WEST SUSSEX COUNTY COUNCIL CONSULTATION

TO:	Arun District Council FAO: Mrs A Gardner
FROM:	Highways, WSCC
DATE:	13/07/2018
LOCATION:	Land to the north of, 68, Arundel Road, Angmering, Littlehampton, BN16 4LL
SUBJECT:	A/31/18/OUT Outline application with all matters reserved for the erection of 2 No. 3 bedroom semi-detached properties with integral garages & associated landscaping works. This application is a Departure from the Development Plan. Amendment Received
DATE OF SITE VISIT:	N/A
RECOMMENDATION:	☒ Advice ☐ Objection ☐ Modification ☐ No Objection ☐ More Information ☐ Refusal
S106 CONTRIBUTION TOTAL:	£N/A See below for breakdown.

TITLE:
SITE BLOCK PLAN

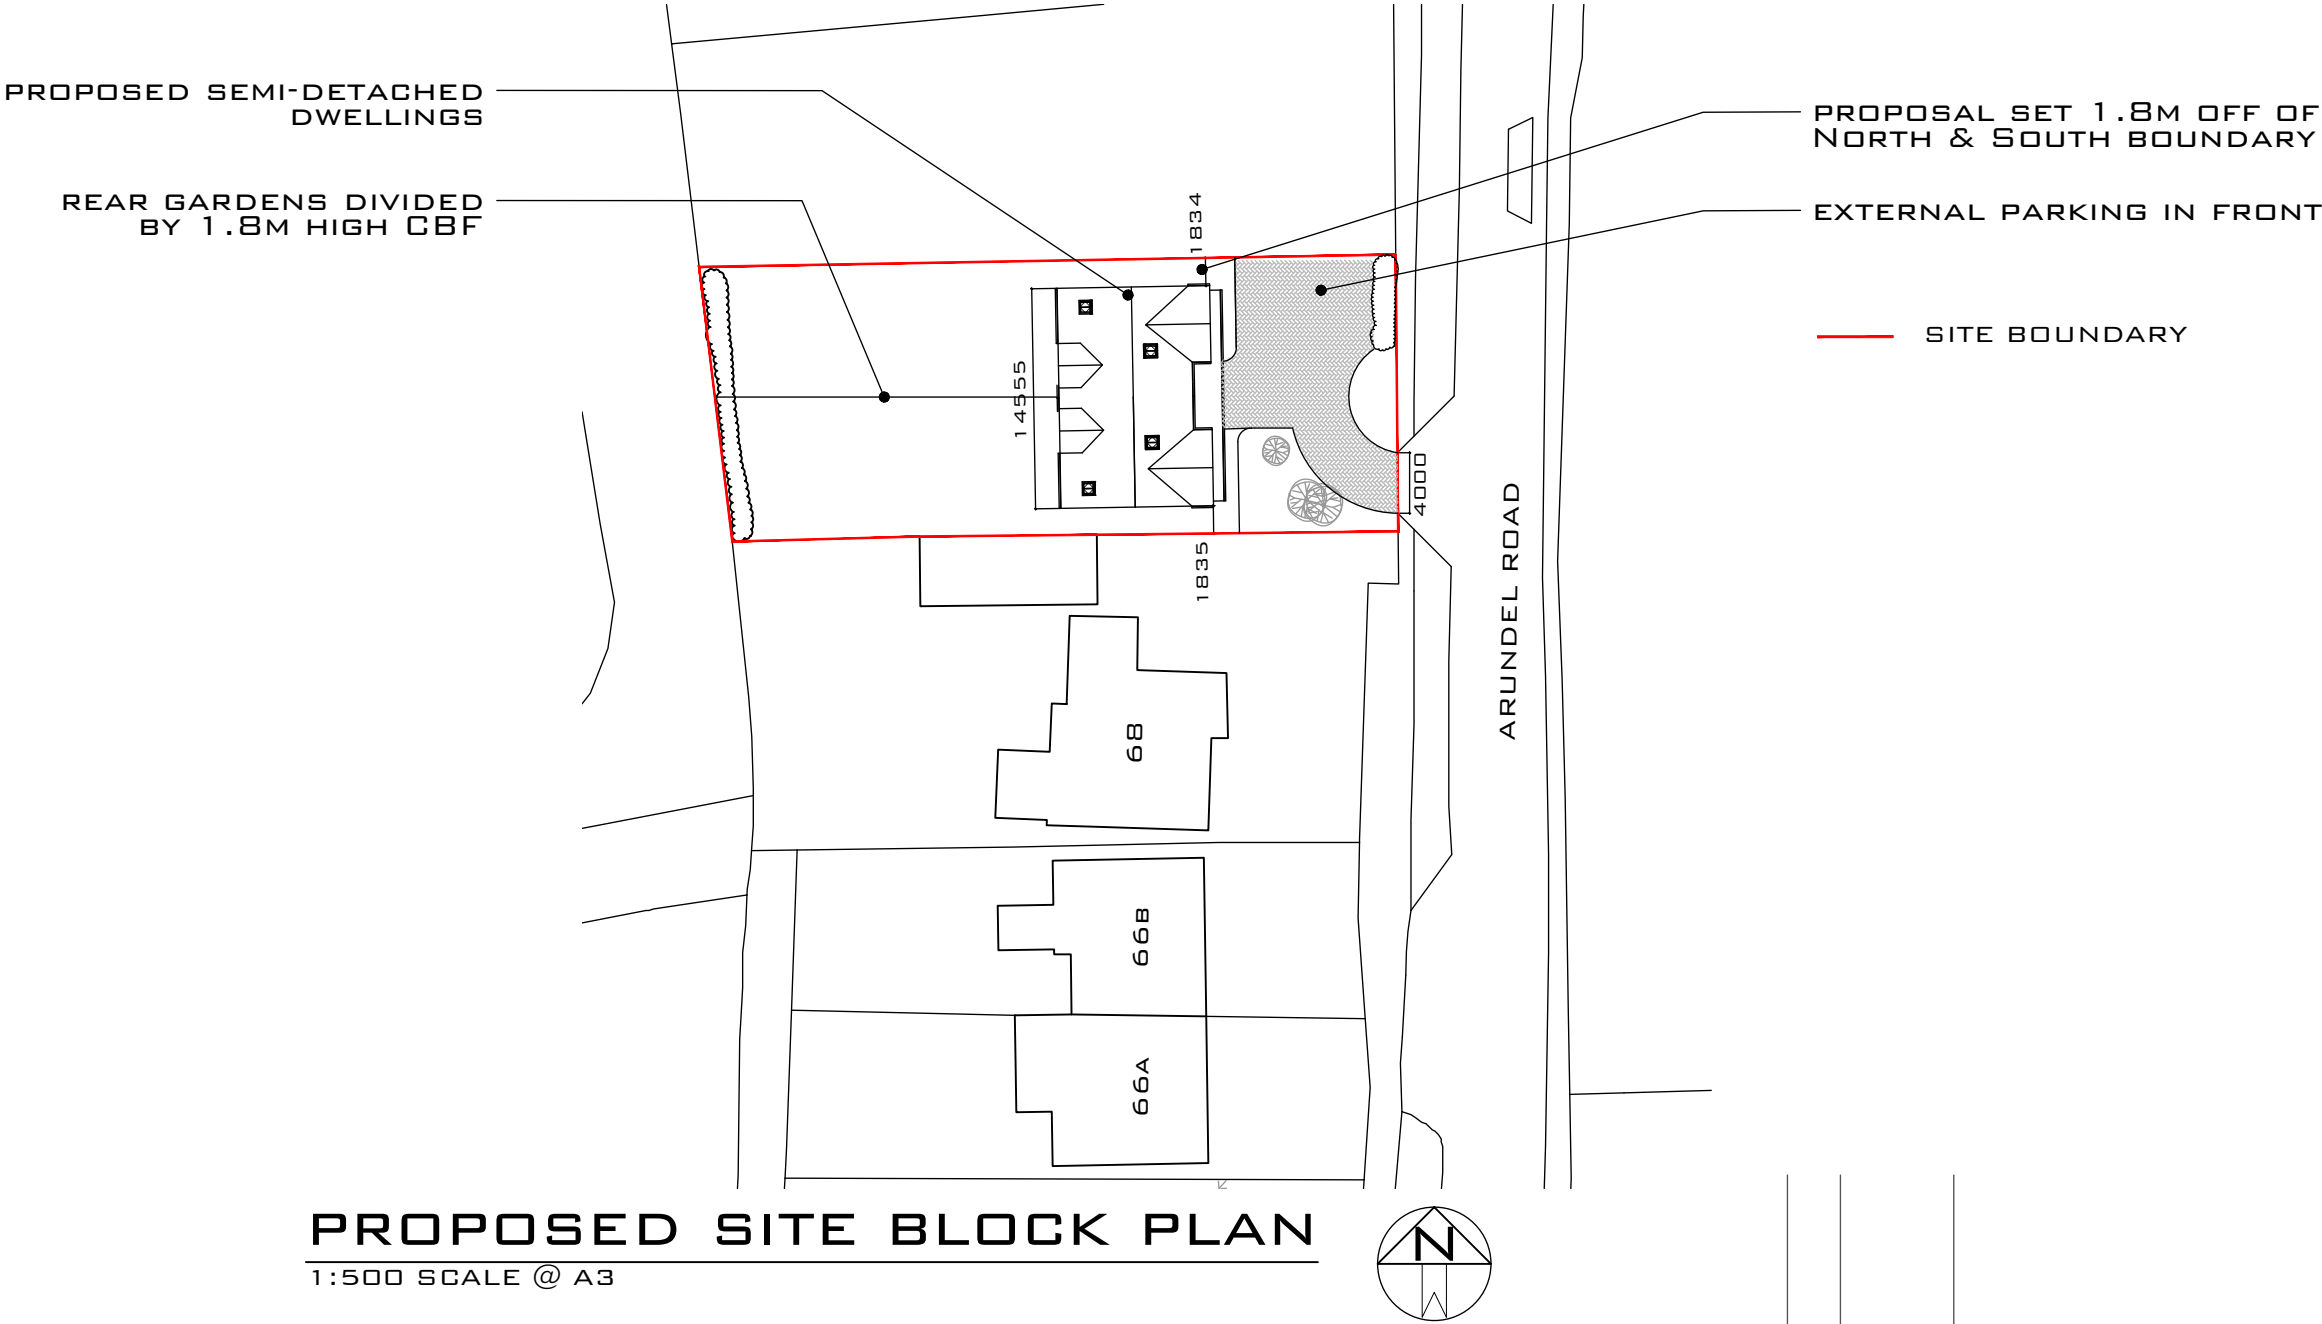
A new 4m wide shared access is proposed onto Arundel Road which should be constructed to a specification agreed with the Local Highways Engineer. Considering the access is to be shared between two dwellings the Local Highway Authority (LHA) advises this be widened to 4.5m to allow two cars to pass within the access.

Pedestrian visibility has not been demonstrated. Whilst the LHA appreciate there is a 1m wide strip of overgrown highway verge there would be benefit to increasing pedestrian visibility splays back into the site, either side of the proposed access. This would require that the proposed access be relocated slightly north. Considering that the LHA have advised that the access is widened we would anticipate that details of the amended access including vehicle and pedestrian splays can be secured at reserved matters stage. Pedestrian visibility splays should be taken 2m back into the access and

a distance measured along the back of the footway for 2m on each side of the access. Boundary treatments should be maintained to a maximum height of 0.6m within these splays.

Vehicular visibility at the proposed access has not been demonstrated by the applicant, however, an inspection of local and WSCC mapping indicates that visibility at this location is sufficient for the posted limit. An inspection of local mapping reveals that 2.4m by 43m is achievable entirely within the publically maintained highway, in line with guidance set out in Manual for Streets (MfS). It would appear that hedgerow within the public highway would require cutting back to maintain these splays. The LHA would advise that splays are demonstrated at reserved matters stage. An inspection of data supplied to WSCC by Sussex Police over a period of the last five years shows that there have been no recorded injury accidents within the vicinity of the proposed site. As such, there is no evidence to suggest that the addition of two dwellings will give rise to a capacity concern or would exacerbate an existing safety concern.

The amended Design and Access Statement details that two parking spaces per dwelling will be provided - a total of four spaces for the development. The WSCC parking demand calculator expects that this is sufficient parking provision for a development of this size and location. The LHA advises that in order for the parking spaces to be counted as allocated parking provision, each space must meet minimum dimensions of 2.4 x 4.8m as set out in MfS. We expect that this would be demonstrated at Reserved Matters stage. A turn on site has not been demonstrated but appears achievable in this location.
